**Addendum No. 1**

RE: Contract ID C203735

NC-55 FROM SR-1105 TO SR-1117 & 20 SECTIONS OF SECONDARY ROADS

**July 21, 2015 Letting**

TYPICAL SECTION 1

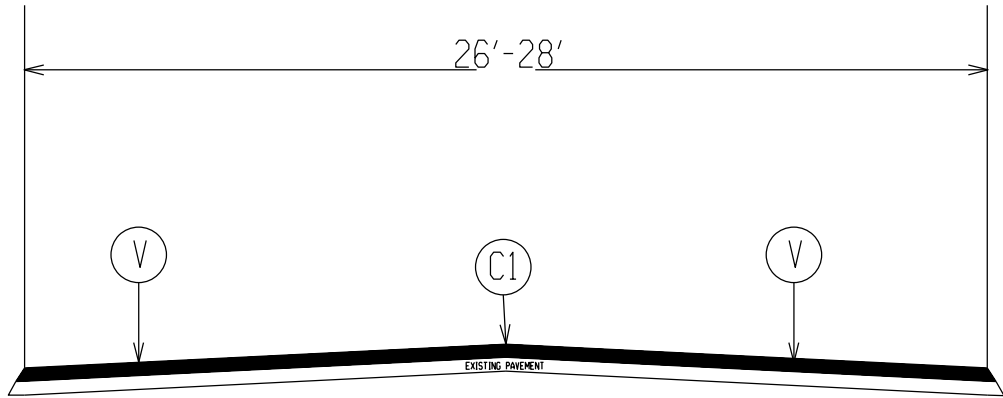
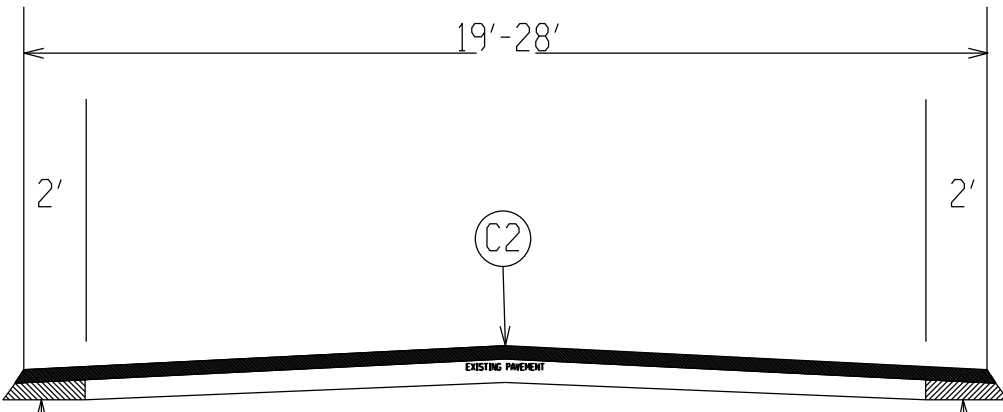
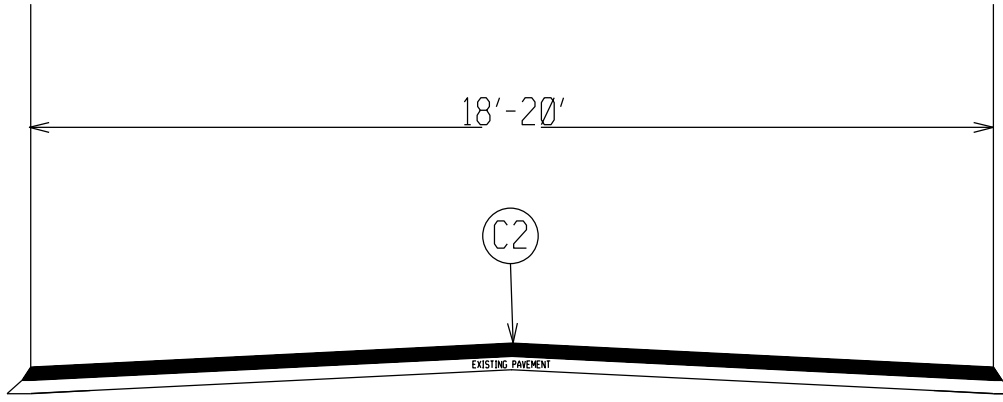
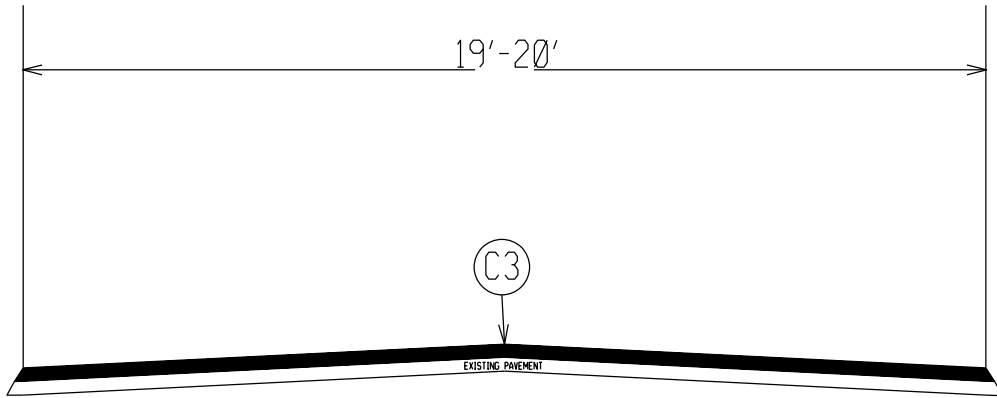
Page No.	Revisions
Proposal Cover	Note added that reads "Includes Addendum No. 1 Dated 07-15-15"
R-7 and R-8	Revised special provision "TRENCHING FOR BASE COURSE"

Perform all trenching necessary to place the asphalt concrete base course widening in accordance with the typical sections, at locations shown on the sketch maps, and as directed by the Engineer.

**Trenching shall be done with a milling machine. The trench shall be the width noted on the Typical Sections +/- 0.1'. If the trench excavation exceeds the 0.1' tolerance, the Contractor will be required to backfill the trench with approved earth material or correct the trench to the proper width at no cost to the Department.**
